Drax BECCS Project Planning Examination 2022-2023	Deadline 2 (D2), February 22nd 2023 Written Representation (WR)
--	---

Author Details	
Name	Dr Andrew Boswell
Position	Scientist and Consultant
A66 Northern Trans-Pennine Project Link Roads Registration	20032289
Organisation	Climate Emergency Policy and Planning (CEPP)
Examination Principle Issues	Climate Change

This Written Representation considers the legal and scientific implications of the land use, land-use change, and forestry (“LULUCF”) greenhouse gas (“GHG”) emissions of the scheme. These are indirect emissions of the project, but comprise a very significant, and centuries long climate change impact associated with the proposed Drax facility.

**Plate 1.1 – Annual Sources of GHG Emissions from the Proposed Scheme**

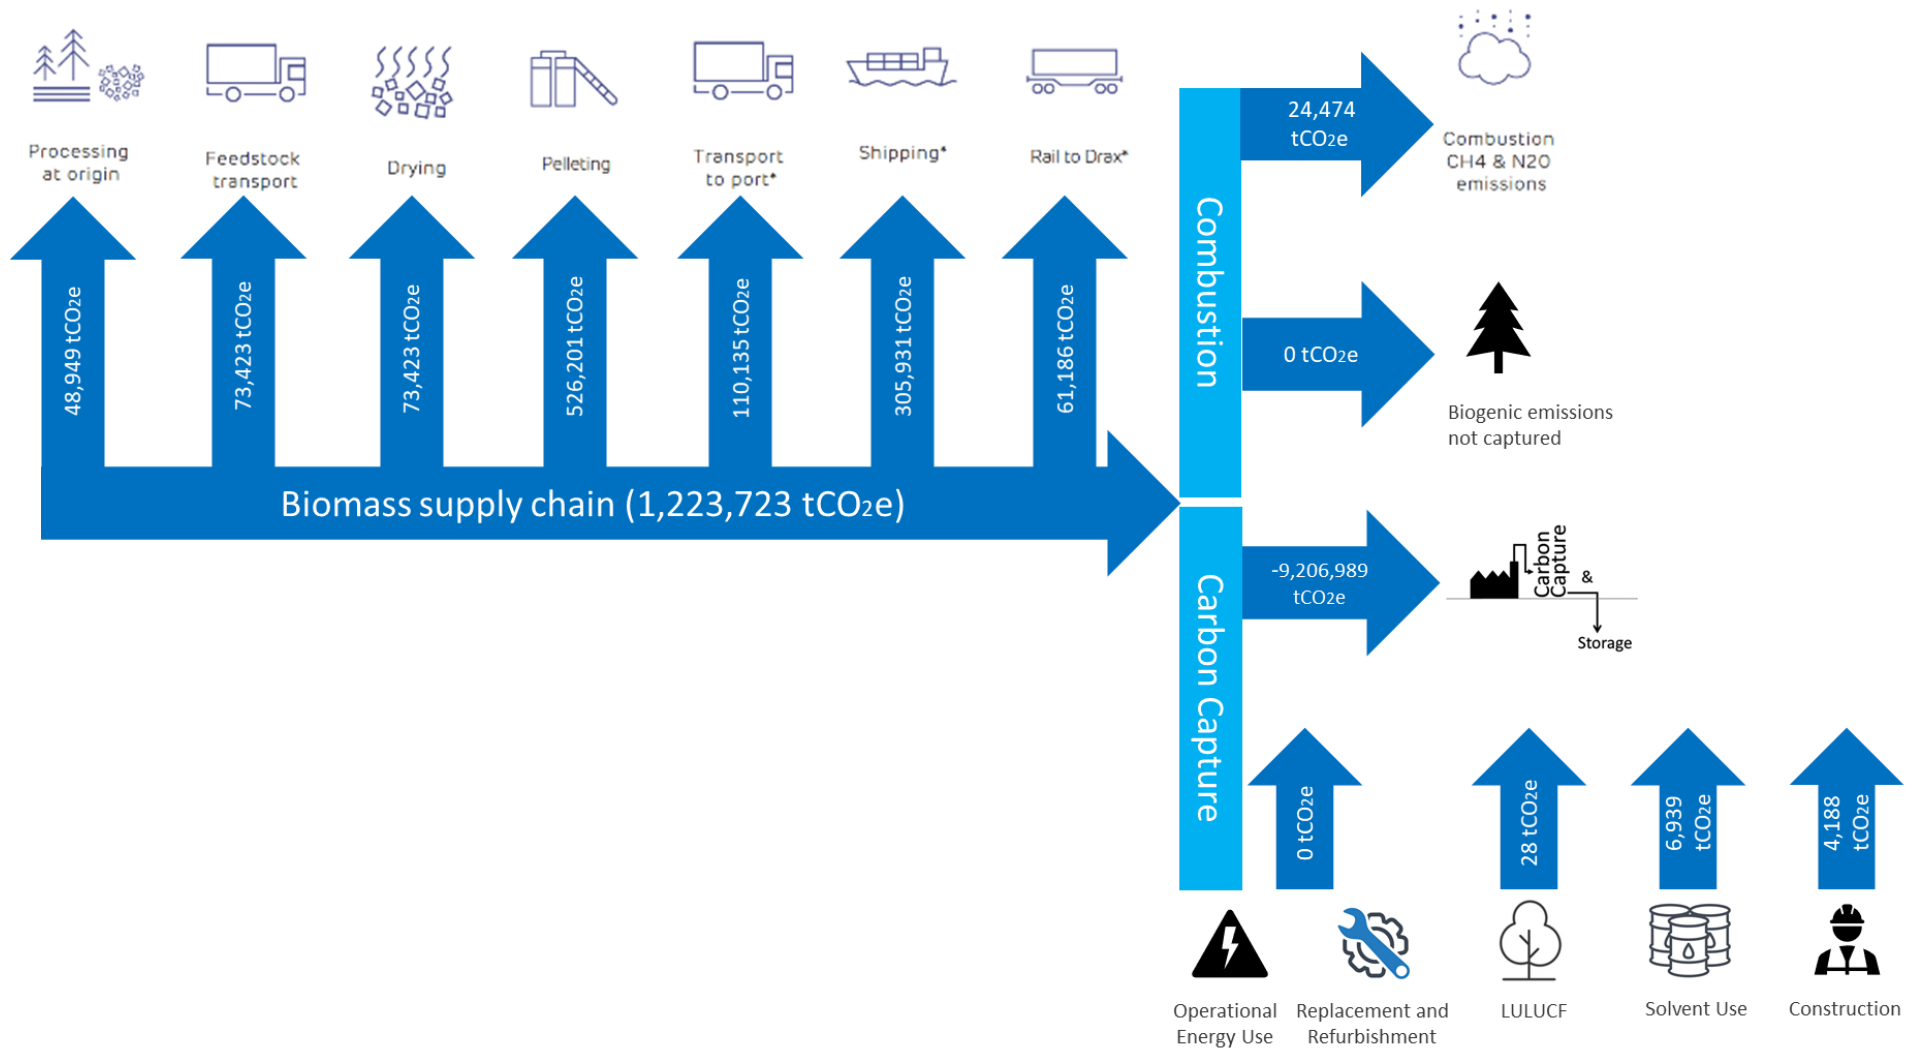
- 17 I am aware that it is because the UK consider “bioenergy to be carbon neutral” that **the LULUCF emissions for the fuel production of wood for Drax have not been accounted for in the ES**. As well as the extremely limited and misleading scoping of LULUCF emissions under PAS 2080, Plate 1.1 in “Appendix 15.2: Proposed Scheme GHG Emissions

Calculation” [APP-169] also makes it clear that the LULUCF emissions accounted for under operational emissions are not from the fuel production supply chain.
